CITY OF ALBUQUERQUE

RE: Star Limo
800 Avenida Caesar Chavez, Albuquerque, NM
Grading and Drainage Plan ⁴
Stamp Date 1/13/2017 (File: L1/D059) ^{MA}

RE: Star Limo
800 Avenida Caesar Chavez, Albuquerque, NM
Grading and Drainage Plan
Stamp Date 11/16/2016 (File: L15/D059) ⁴ AC

RE: Star Limo resubmittal- file L14D059

GRADING AND DRAINAGE PLAN

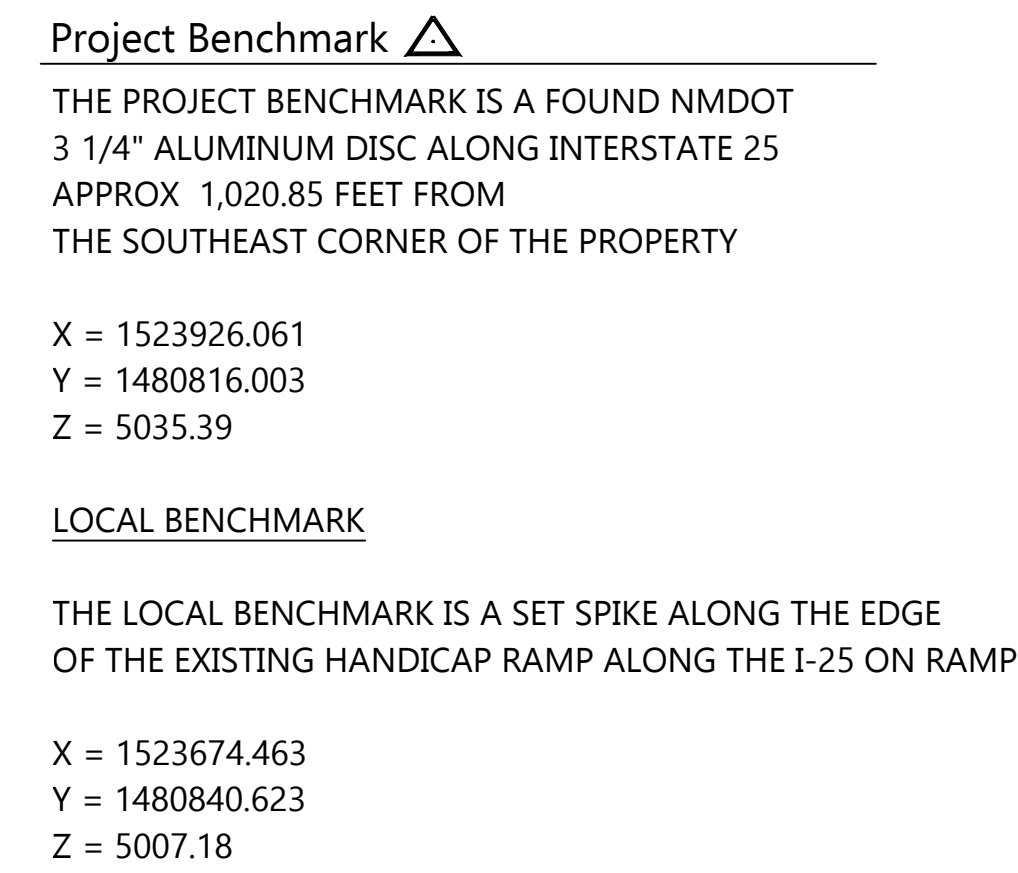
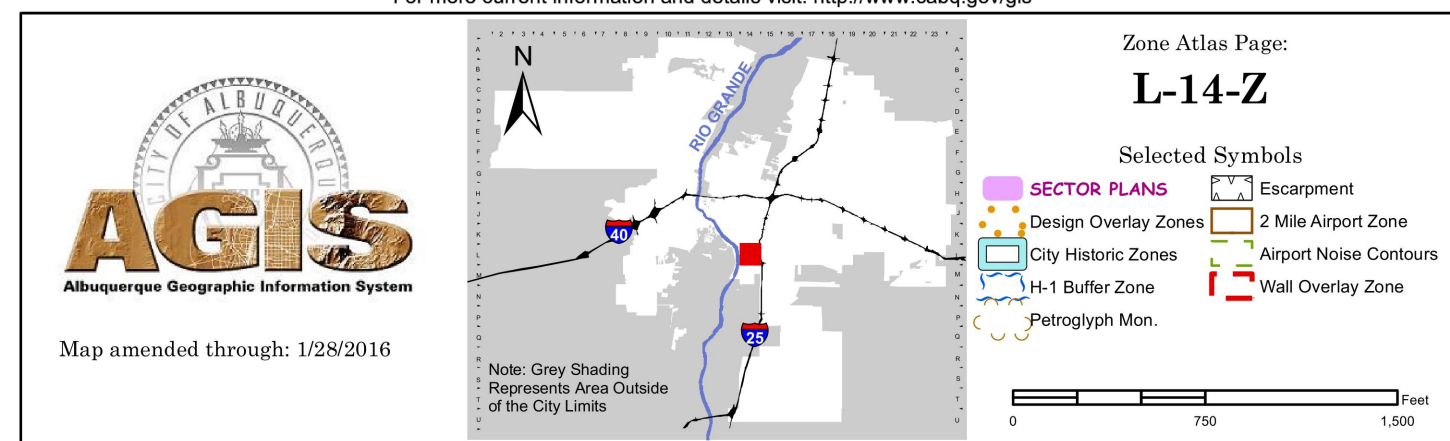
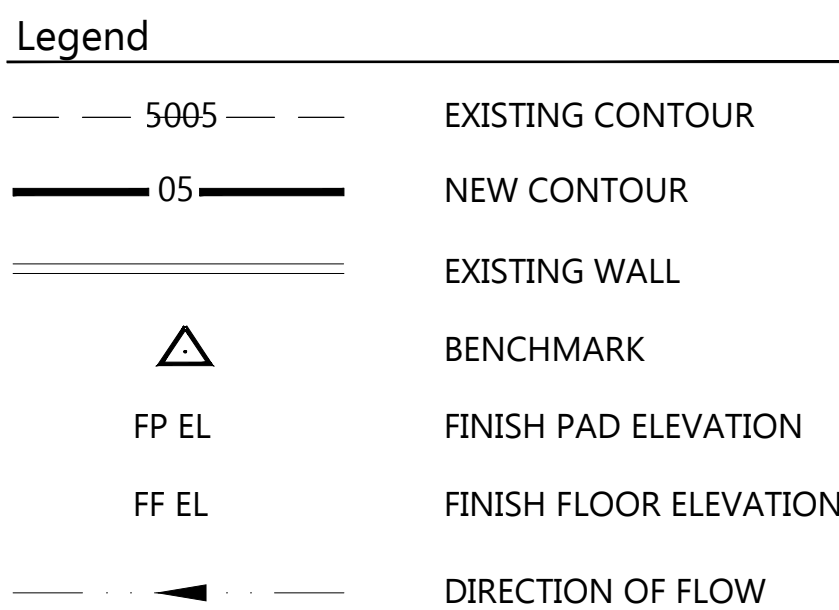
1. Provide existing spot elevations and/or contours to review the proposed grades.
2. Provide calculations for the stormwater quality volume.
3. It appears that a majority of the parking lot drains out the drive entrance rather than into a stormwater quality pond. If this area is impervious it is to drain to a water quality pond prior to discharging to the street.
4. Provide the water service elevation for the stormwater quilted volume.
5. Show Property Lines; does this project impact the NMDOT right of way?
6. Include a legend for the hatch areas.
7. Provide the monument for the benchmark and vertical datum.
8. The culvert plate needs to be extended 1-foot behind the side walk.
9. The narrative states there are three flush water ponds, when there is only one.

Response: The existing contours have been included with this plan.

Response: Pond Volume Calculations have been added.

Response: A water block will be installed at the rear of the drivepad to allow for direction of the runoff to the water quality pond prior to discharge to the street.

Response: the water surface elevation has been added to the current design.

Response: The property lines have been called out. No the grading work will be contained within the project site.

NO Response: A legend has been added.

7. Provide the monument for the benchmark and ~~vertical datum~~ *NO*
Response: The benchmark information is shown on the plan.

8. The culvert plate needs to extend 1-ft behind sidewalk.
Response: the adjustment has been made on the detail clarifying this requirement. *NO*

OK 9. The narrative states there are three flush water ponds, when there is only one.
Response: The narrative has been revised to clarify the current design.
